Sent: 11 September 2026 14:52
To: DC Admin
Subject: Scholes Cricket and Athletic Club

Application reference : 2026/92200/E

I object to this application.

Client	Scholes Cricket Club
Project	Scholes Cricket Club, BD19 6NN
Title	Tree Protection Plan
Drawn By	BA26282TPP
Date	1:300 @ A1
Drawn By	19/06/2026
Drawn By	JE SB
Drawn By	SB

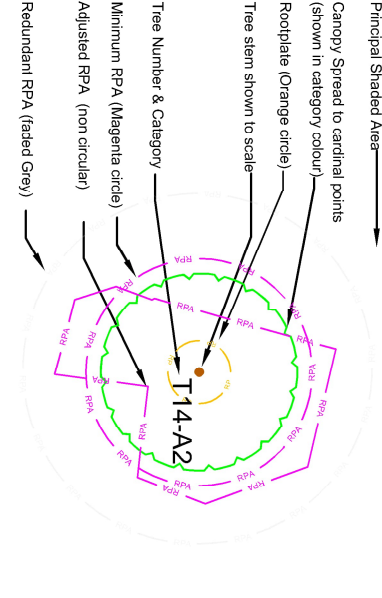
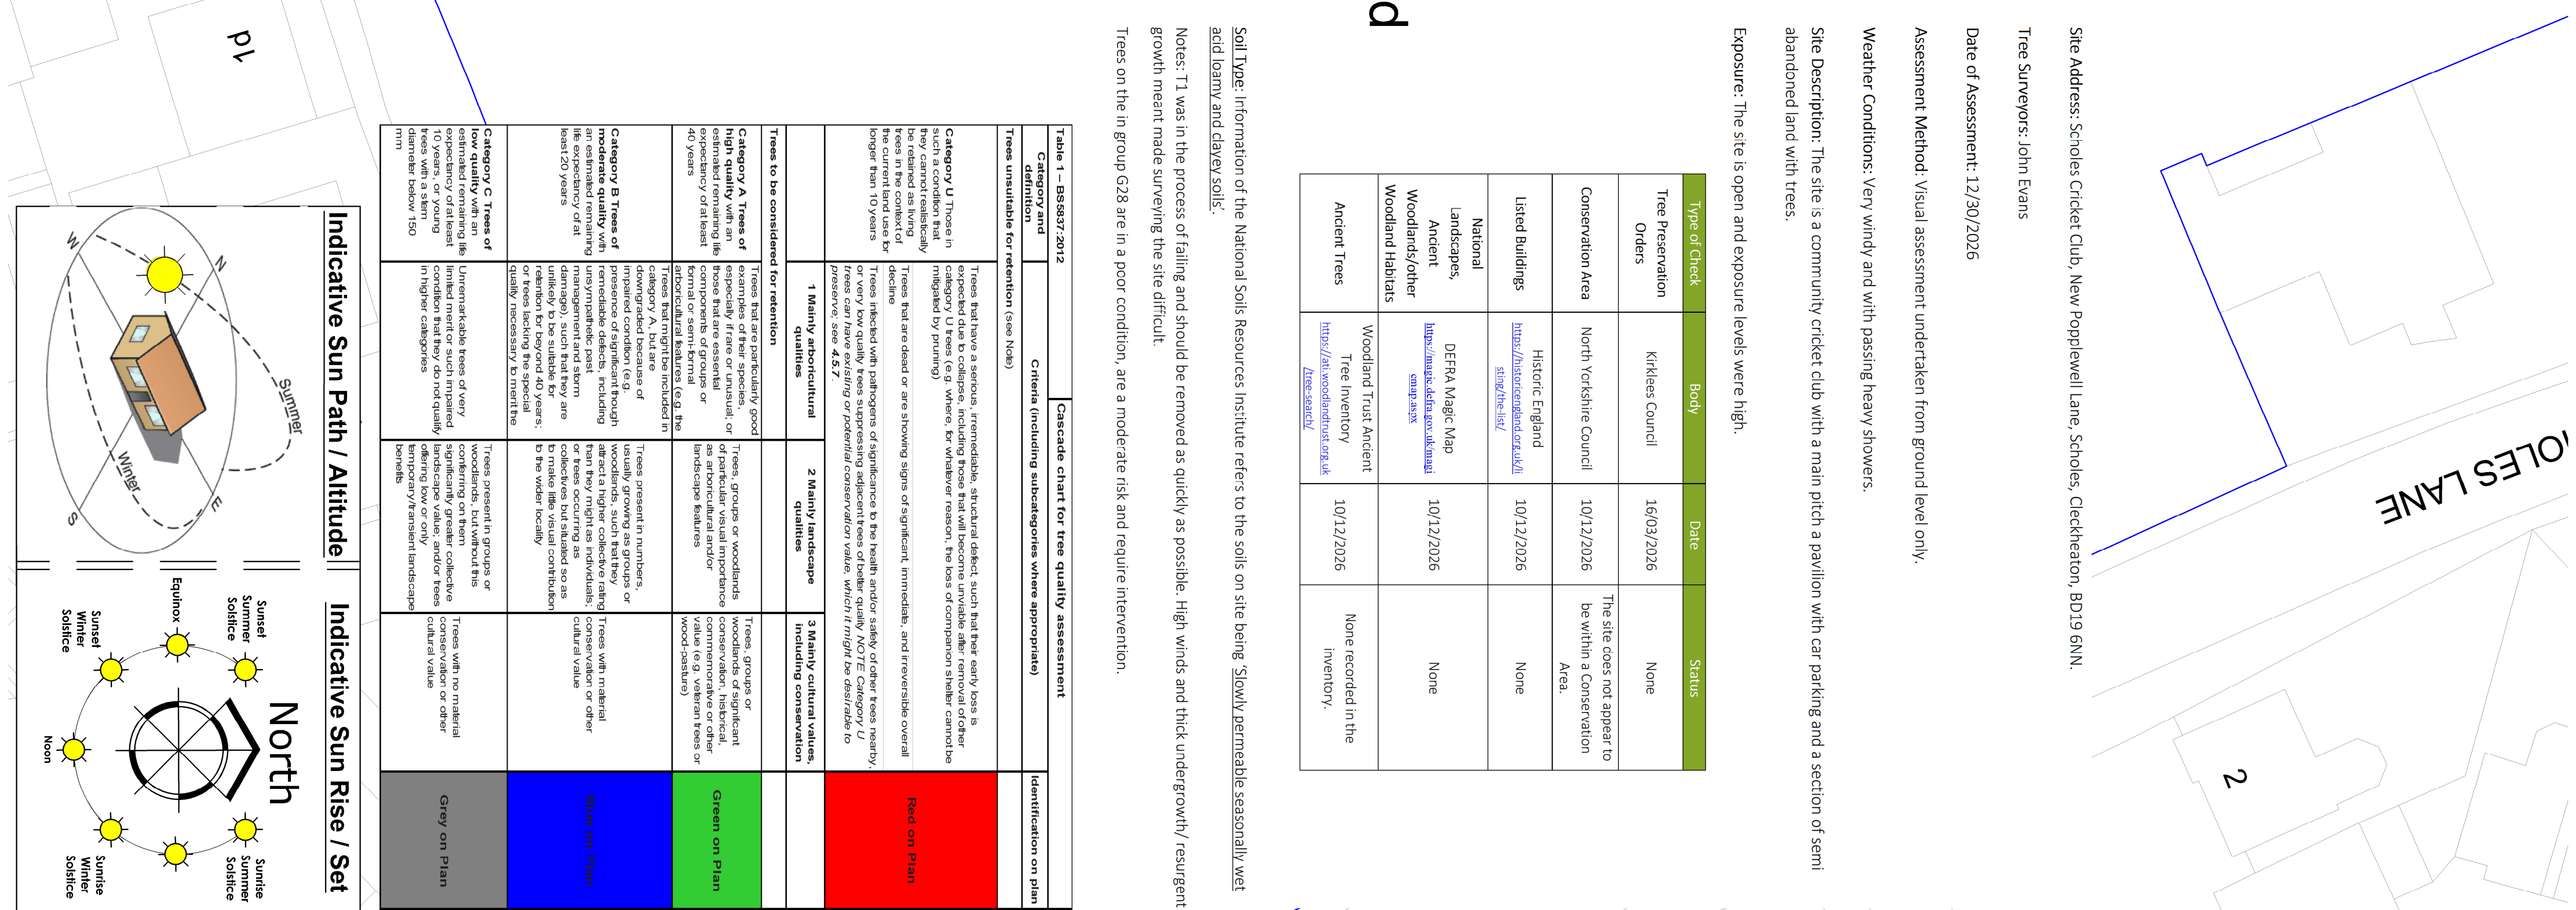
Trees T1, T2, and T3 are recommended for removal on the basis they are "causing damage to the boundary wall and a neighbours garage" I oppose the removal and do not accept the statement. The wall has stood since the house was built in 1978 and OUR wall and garden has never been affected by the trees, or their roots.

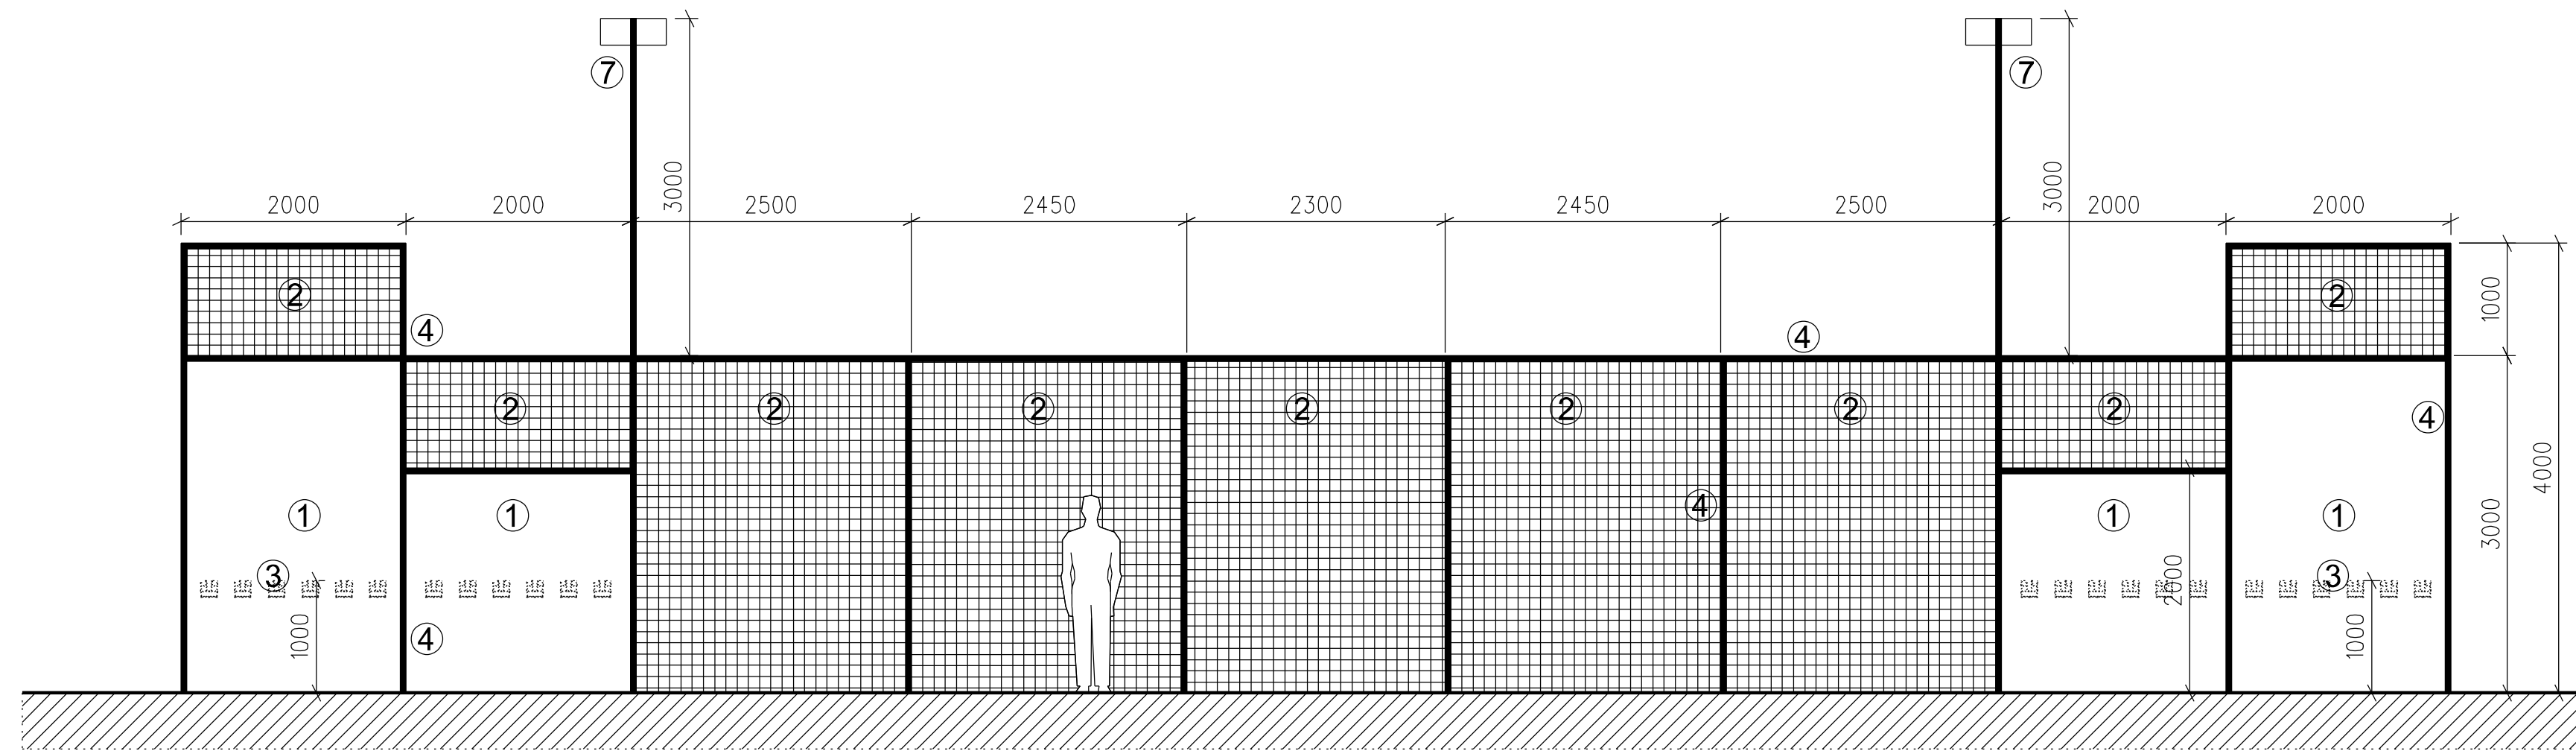
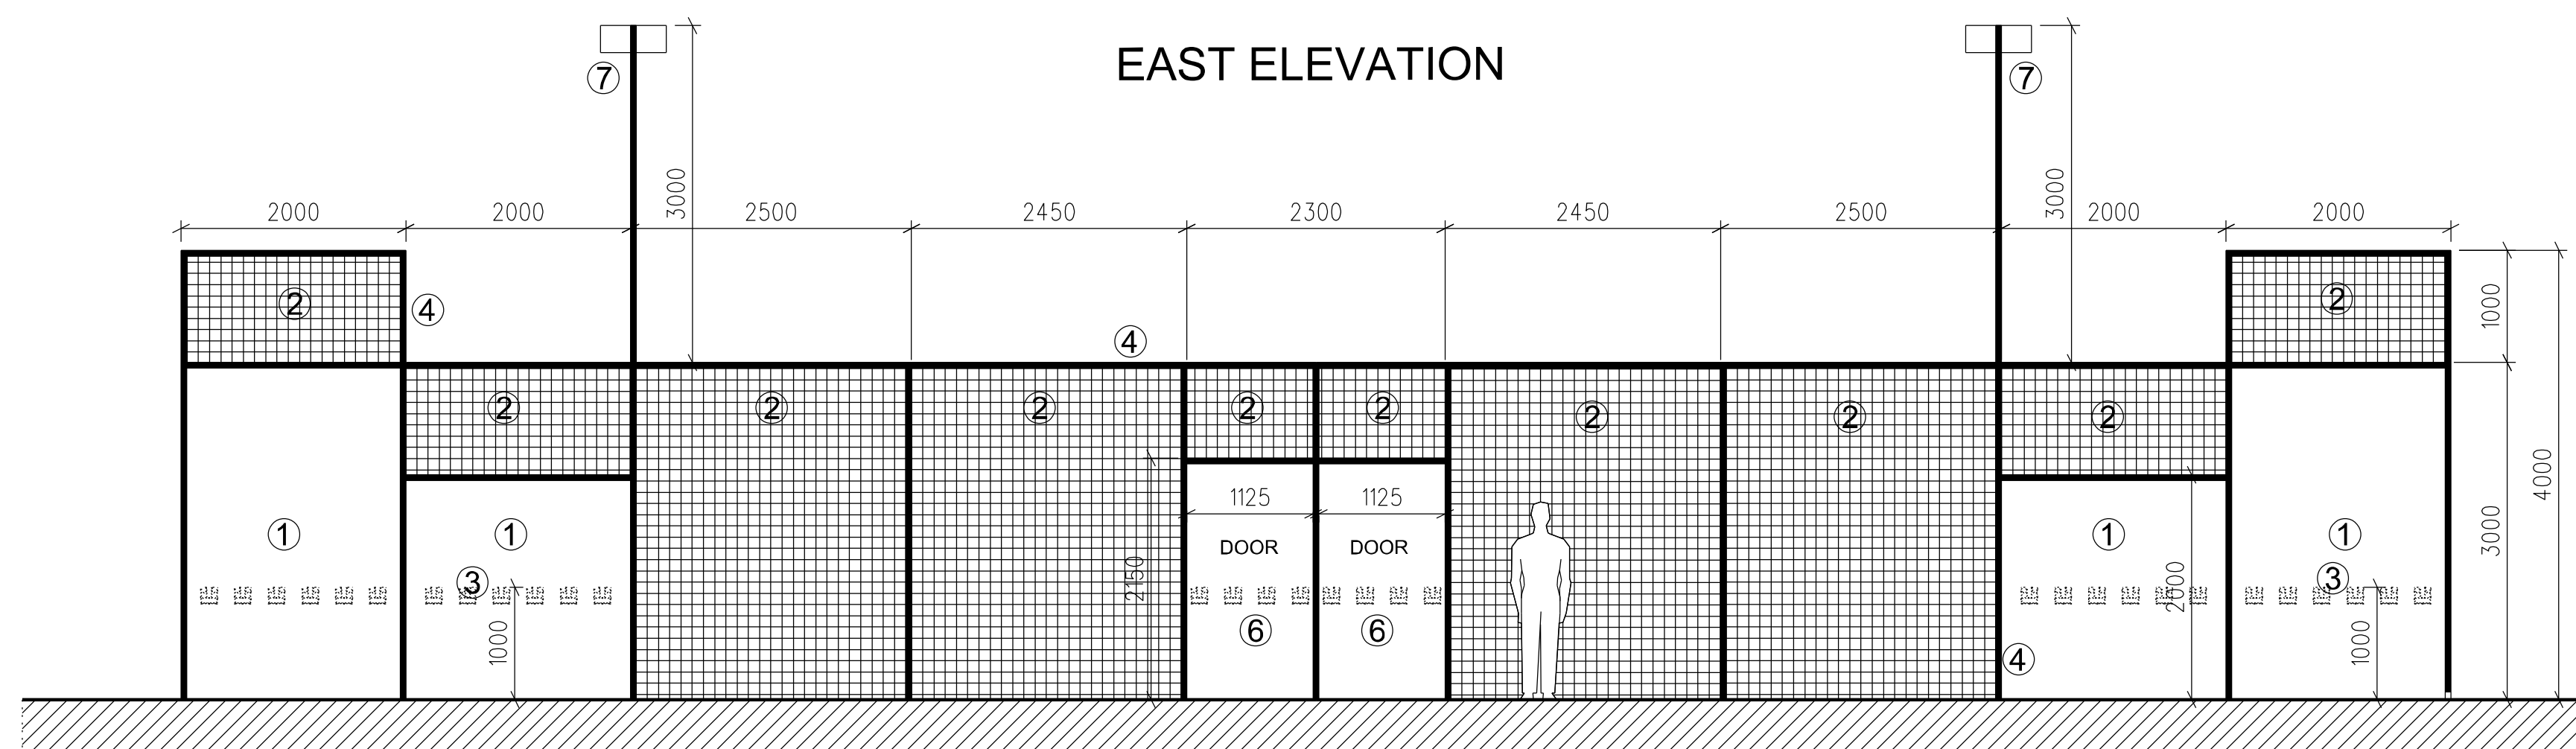
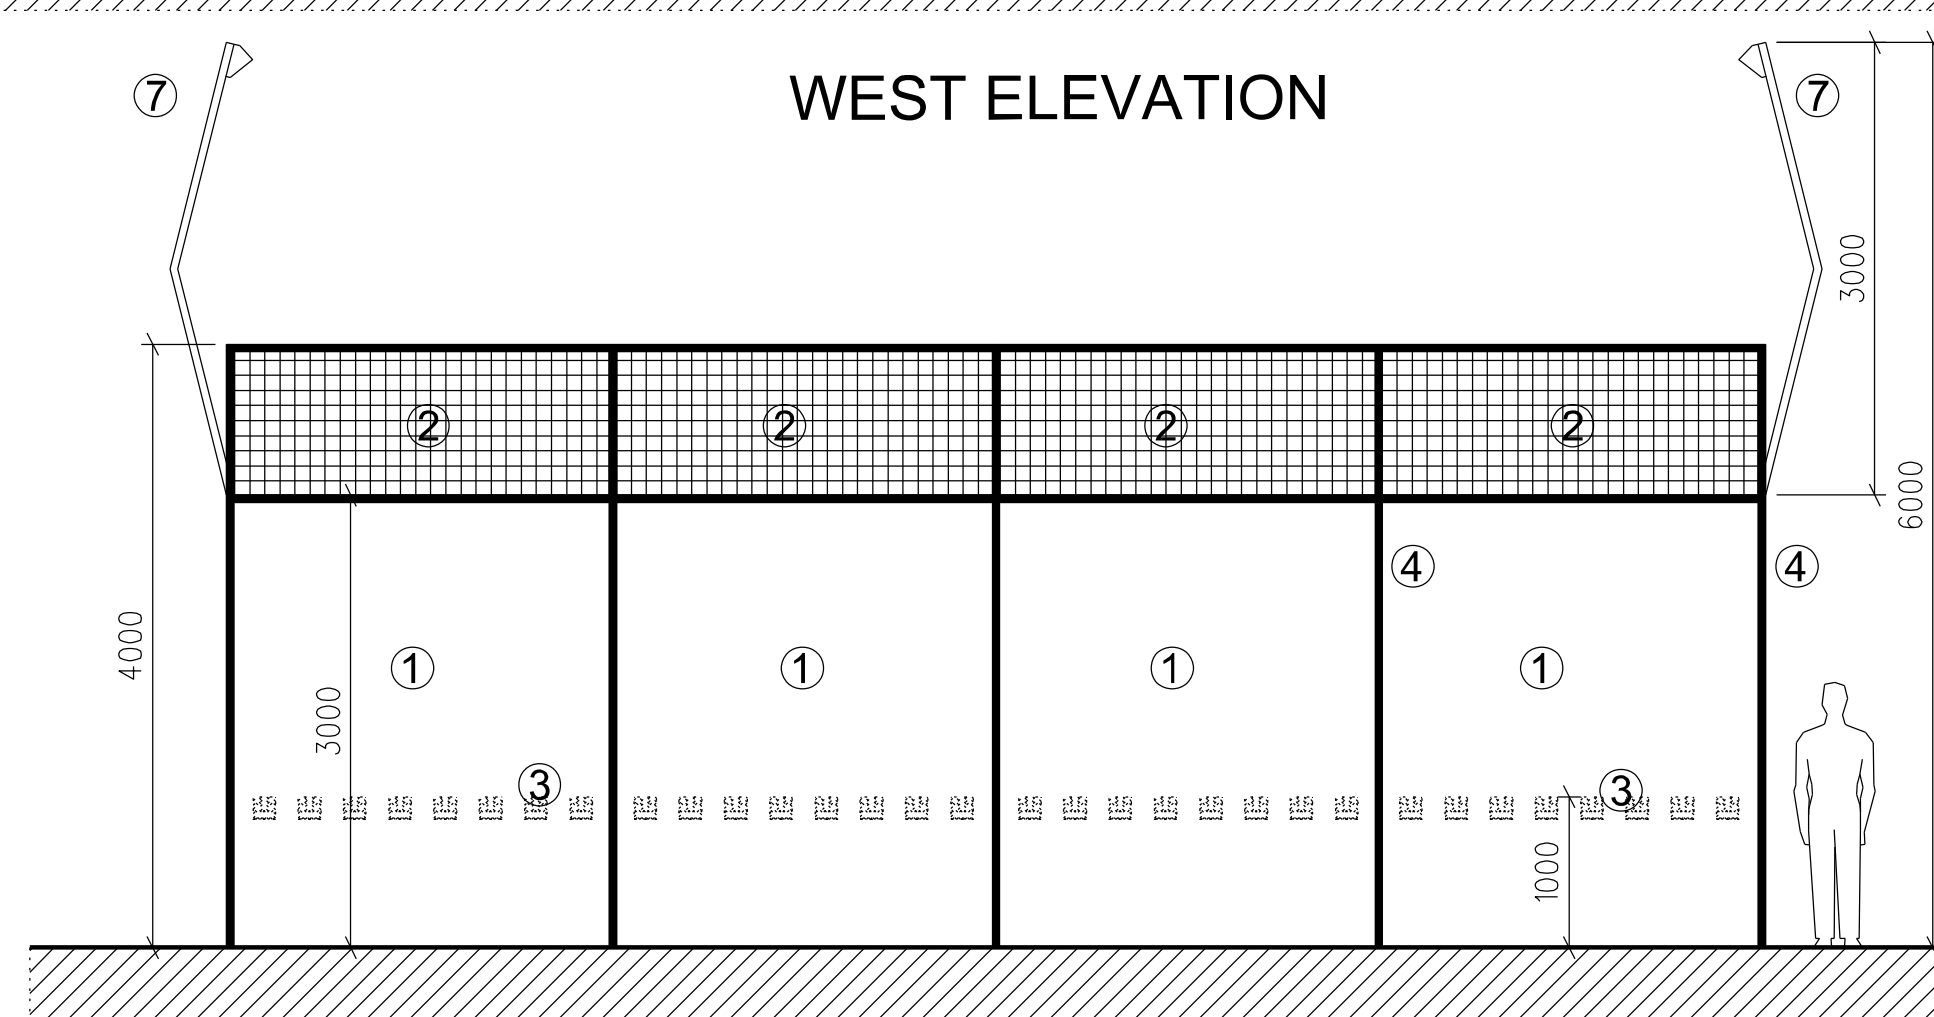
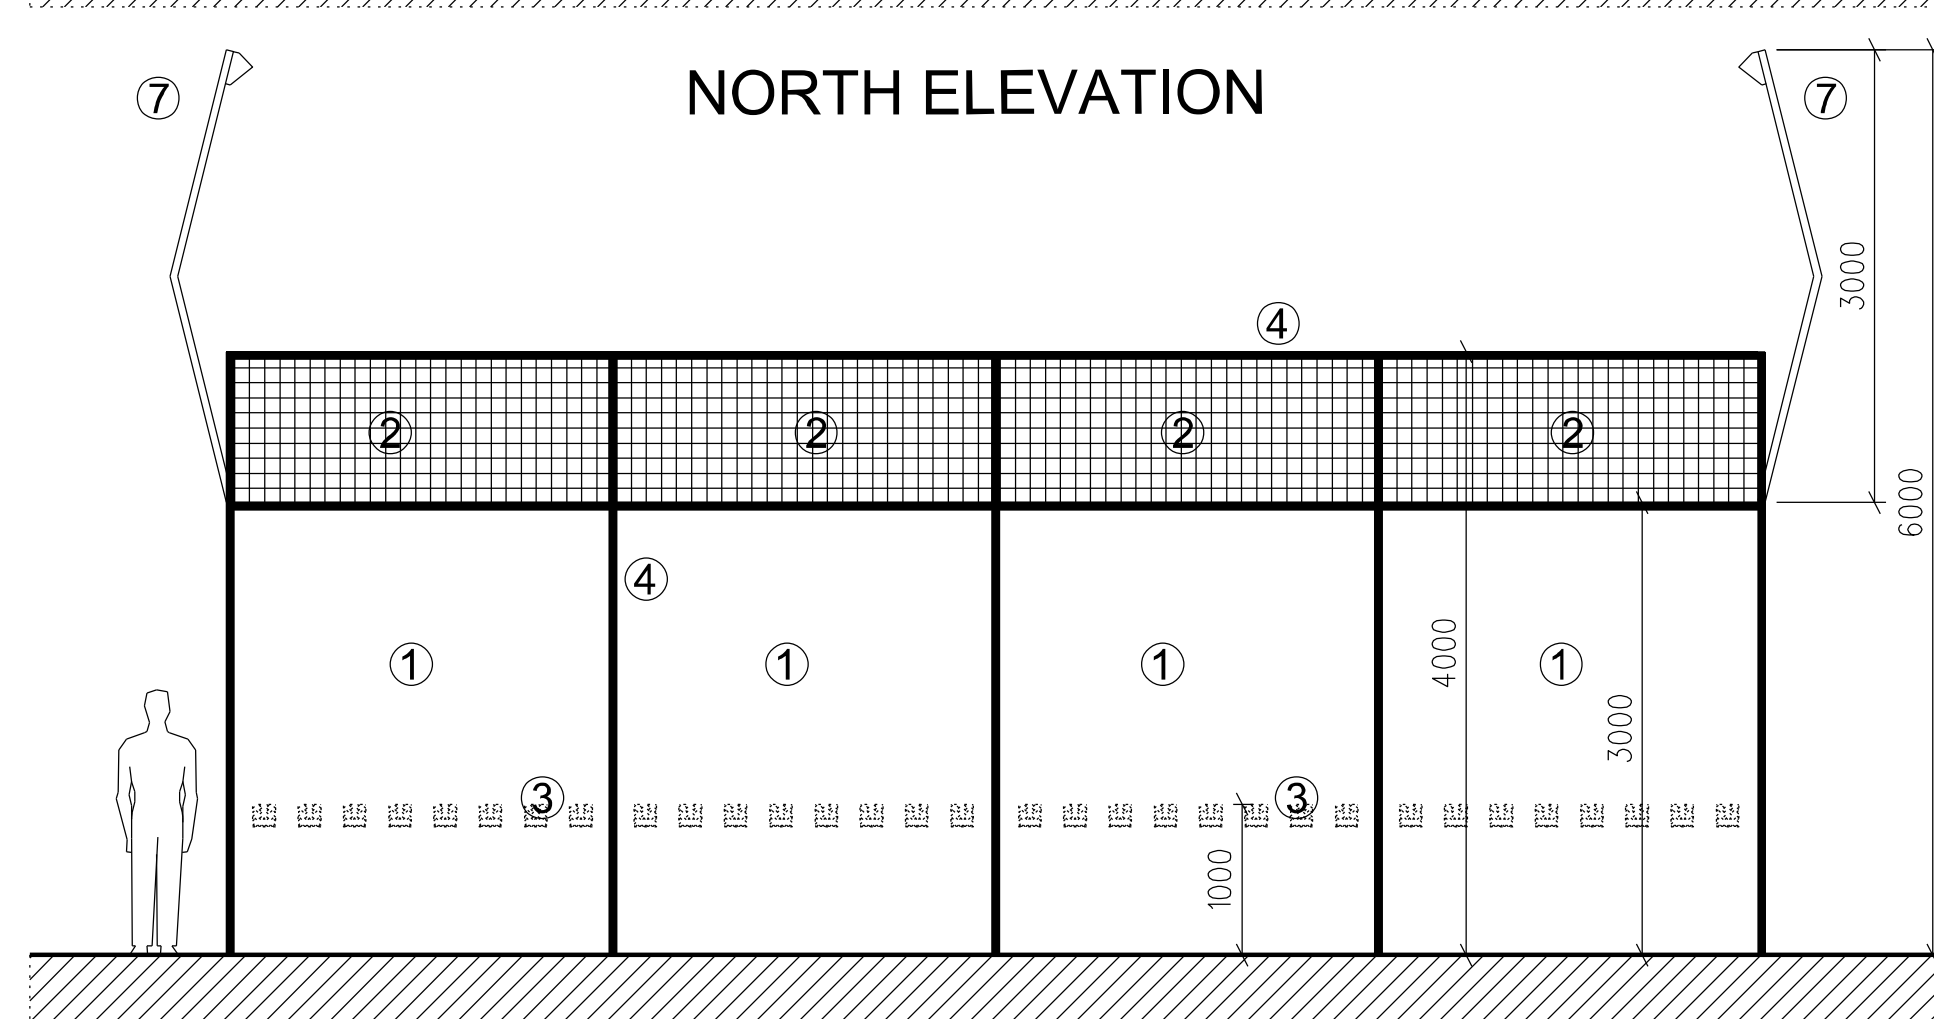
Only states" Floodlights would be installed" and " Floodlights to a special design" Drawings show 8 lighting columns 6 metres in height.
